From: Shena MacDonald [REDACTED]
Sent: Thursday, November 06, 2025 17:07
To: Green Hill Solar <greenhill@planninginspectorate.gov.uk>
Subject: Relevant Representation by Shena Howell FBC187B59 (P&C)

Re. Green Hill Solar Farm – Appendix 16.2 BESS Fire Emissions Modelling May 2025 APP-167

Title:  
Figure 16.4 BESS Fire Emissions Study Area,  
Receptors and Modelled BESS Locations

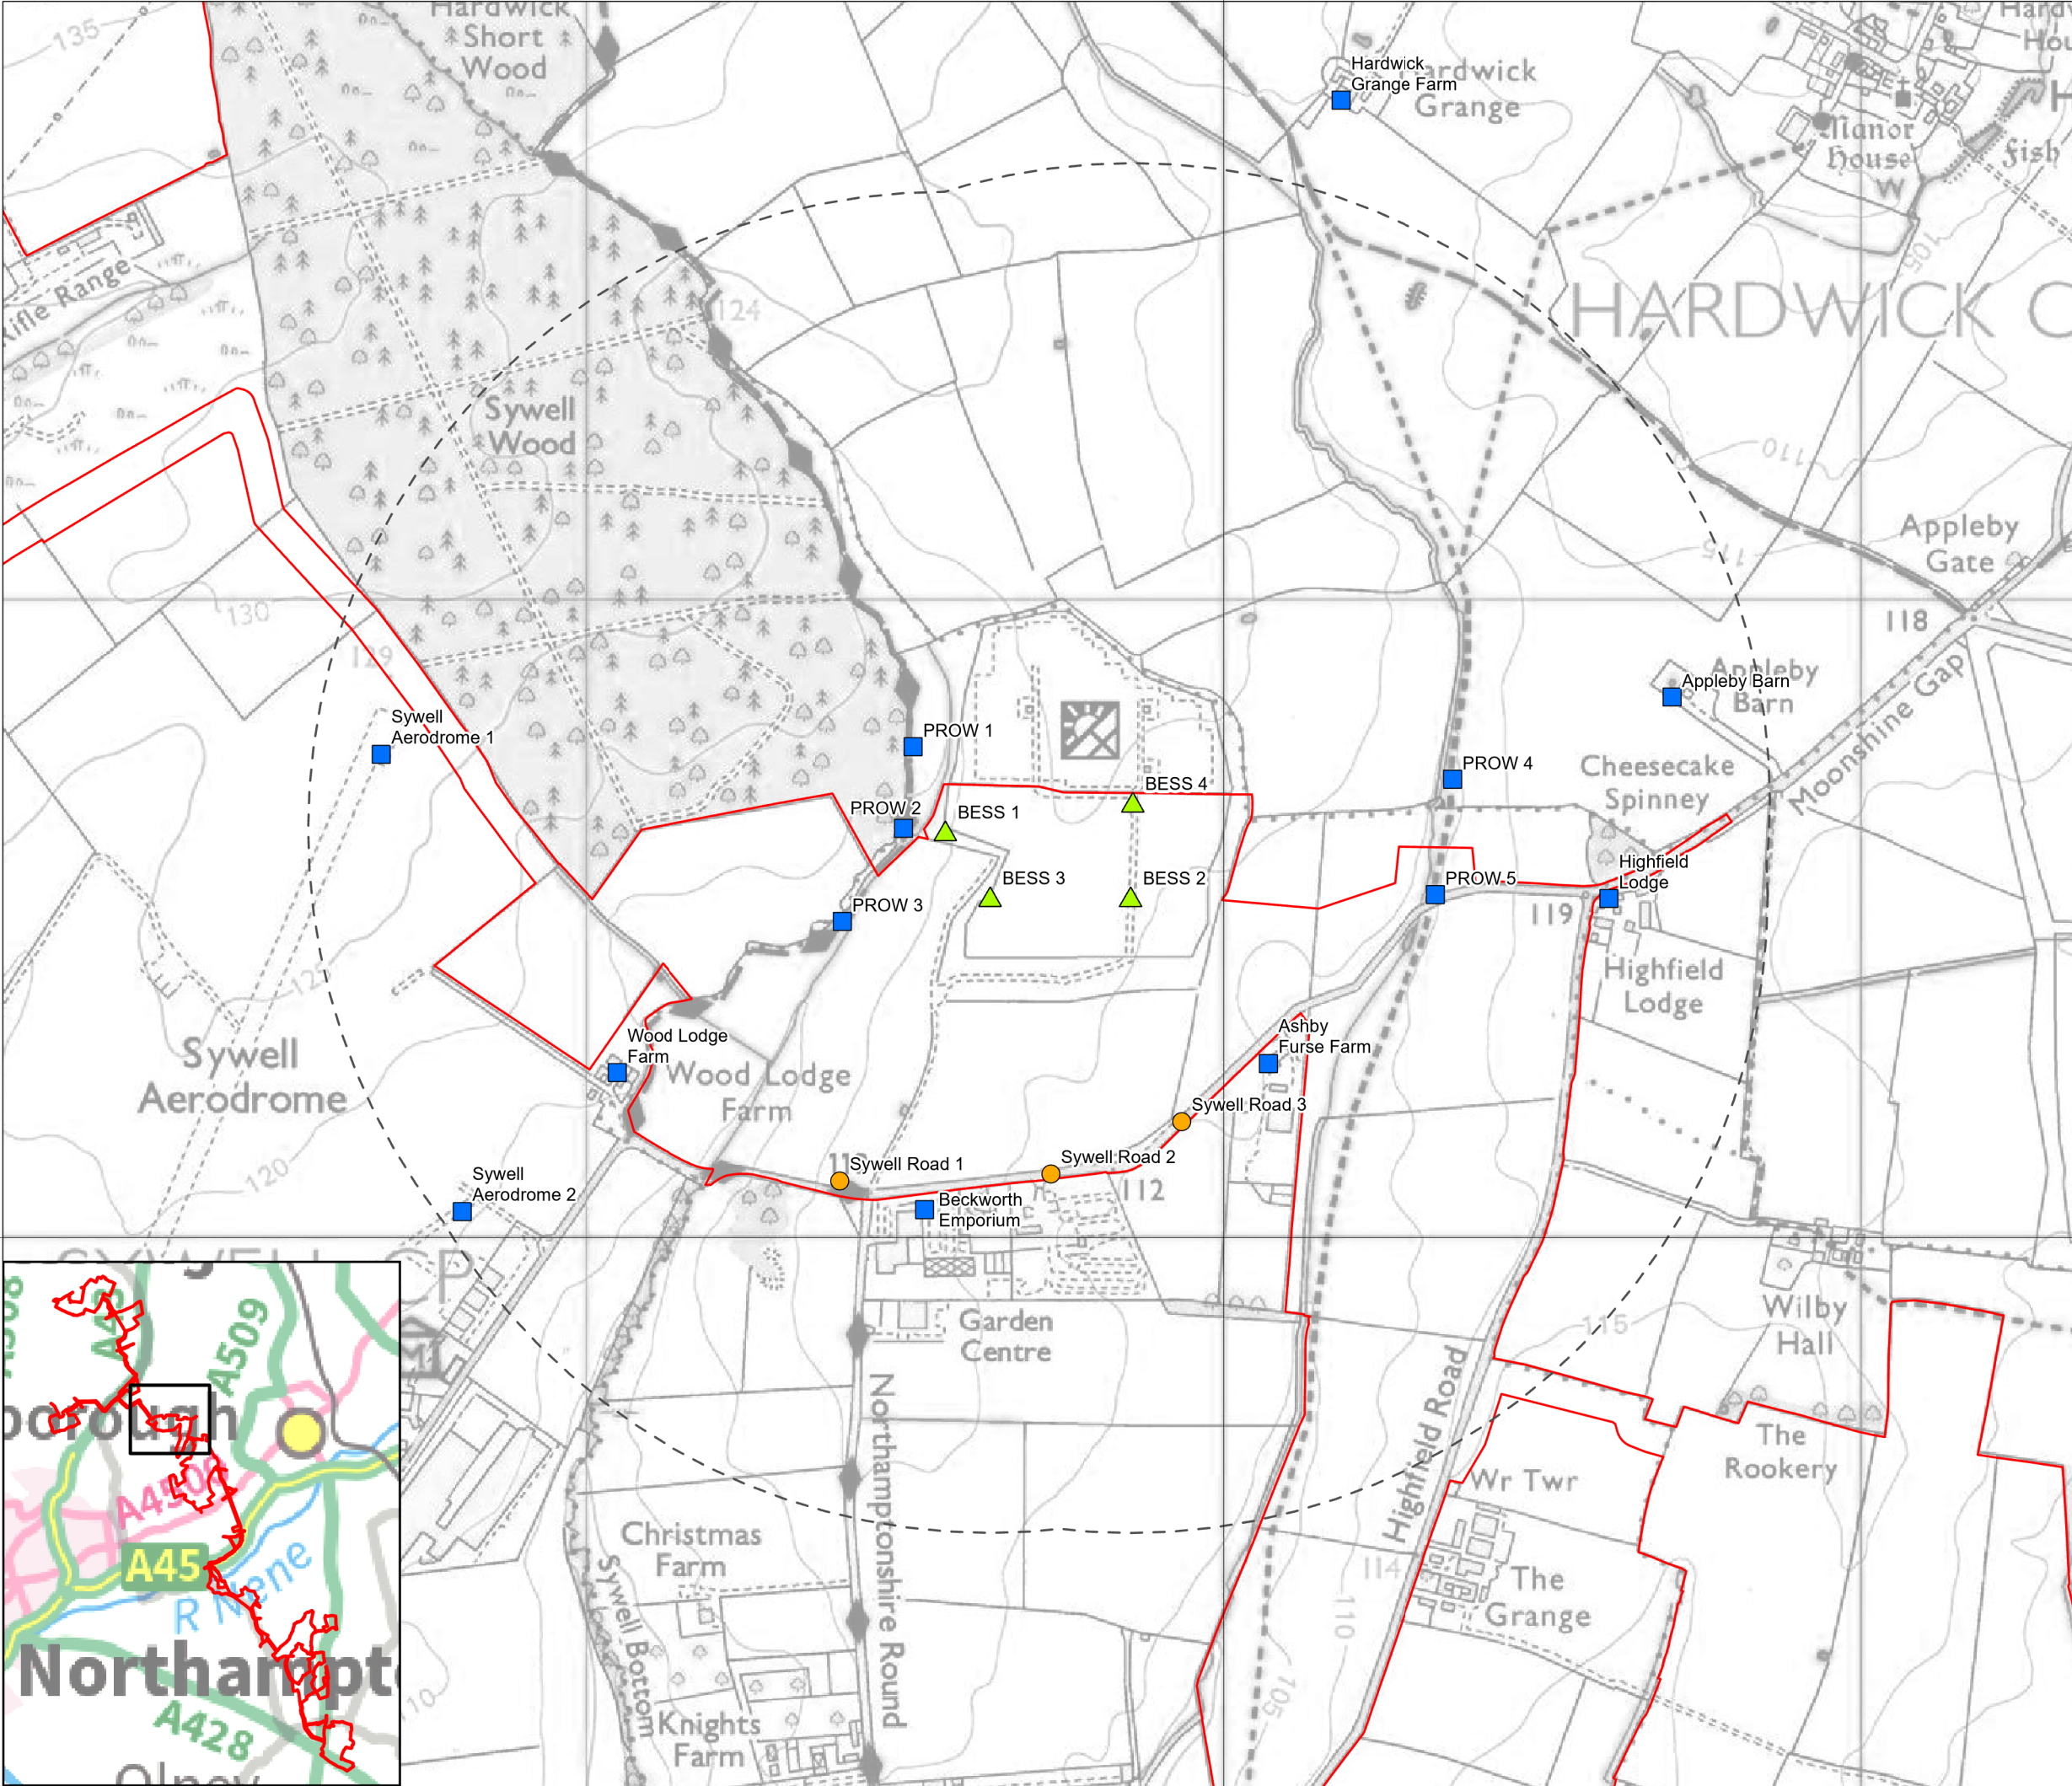
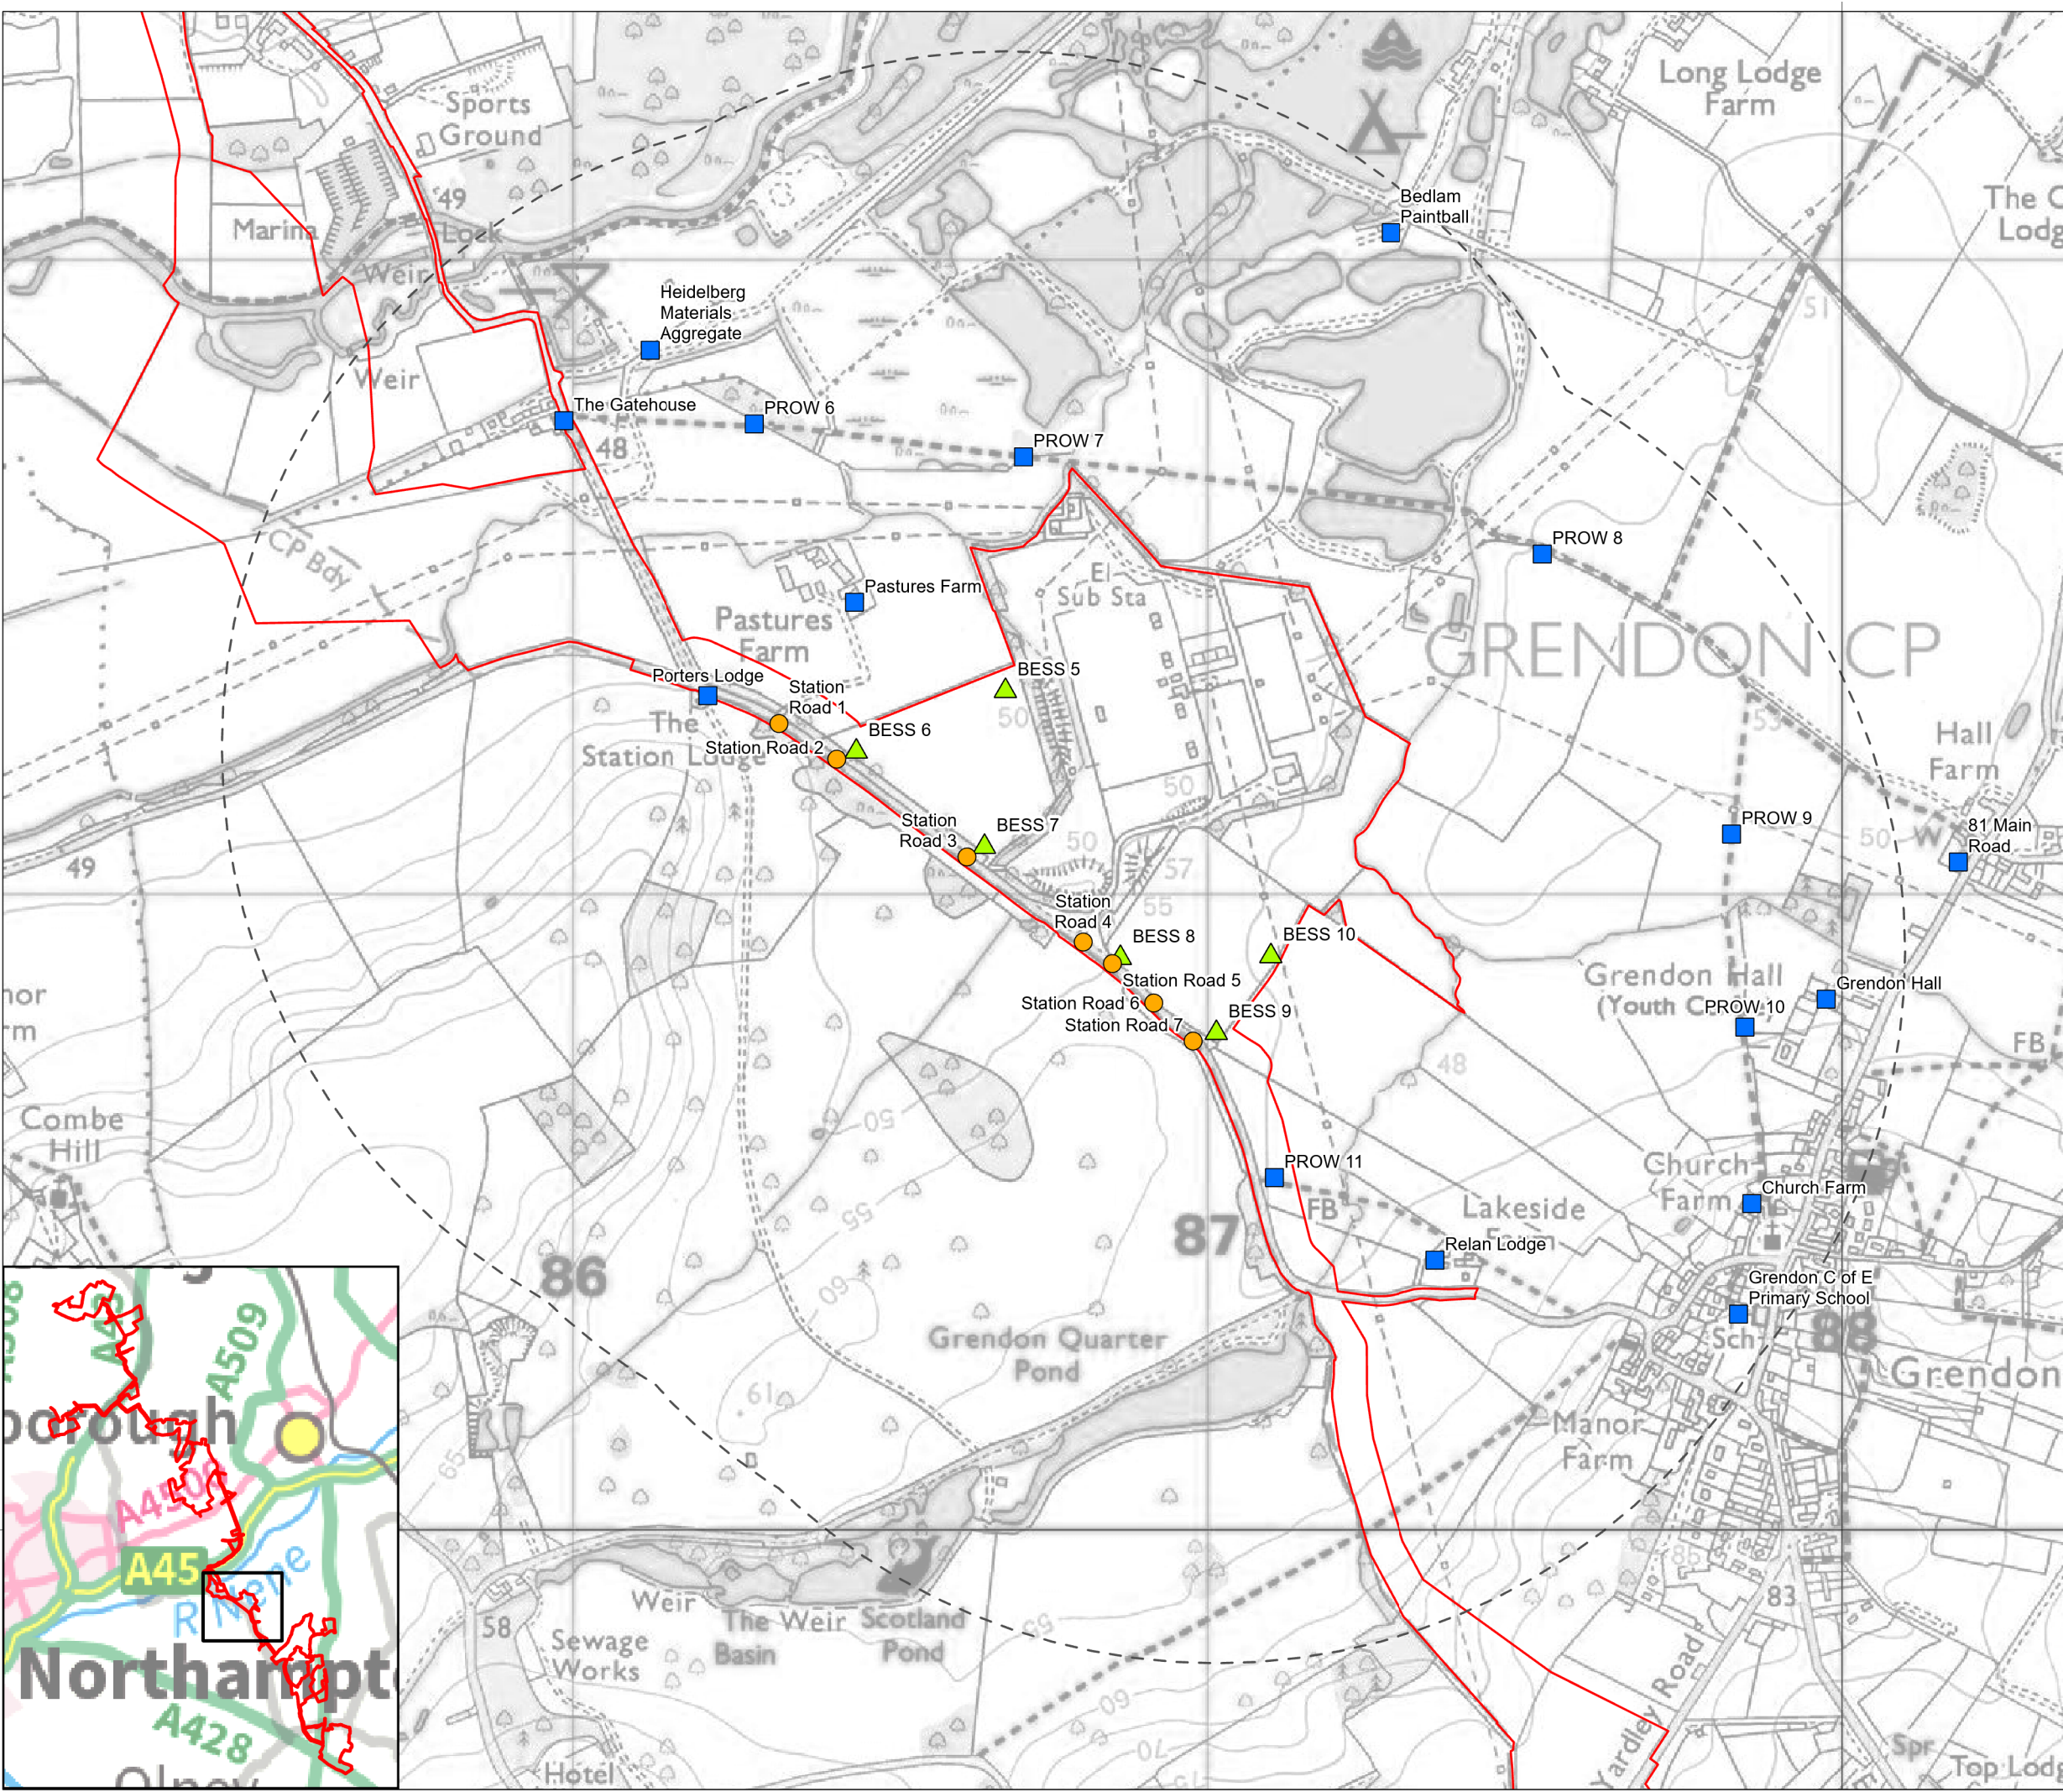
In the same report, the applicant includes much information about plume modelling, but no detail with regards to particulates. (Most of which would be toxic to human health and the environment).

“Each of the modelled ten BESS fire locations have been modelled as an area source so that plume rise was factored into the model (the model does not allow for plume rise for volume sources). The area source dimensions have been based on the dimensions of one BESS enclosure (605.8cm wide and 259.1cm long).”

This clearly under represents the dangers of a thermal runaway incident which potentially occurs when several hundred BESS enclosures are placed in close proximity, as the plans currently assume. Modelling just one container is clearly unrepresentative.

Q. Why has the applicant only looked at fallout within a 1km radius when the experience from other fires is that the particulates travel significantly further than 1km?

The proposed Grendon BESS is only 201/238 metres away from the nearest residential dwellings and only 800m from Grendon, a village of some 550 souls and a Primary School.
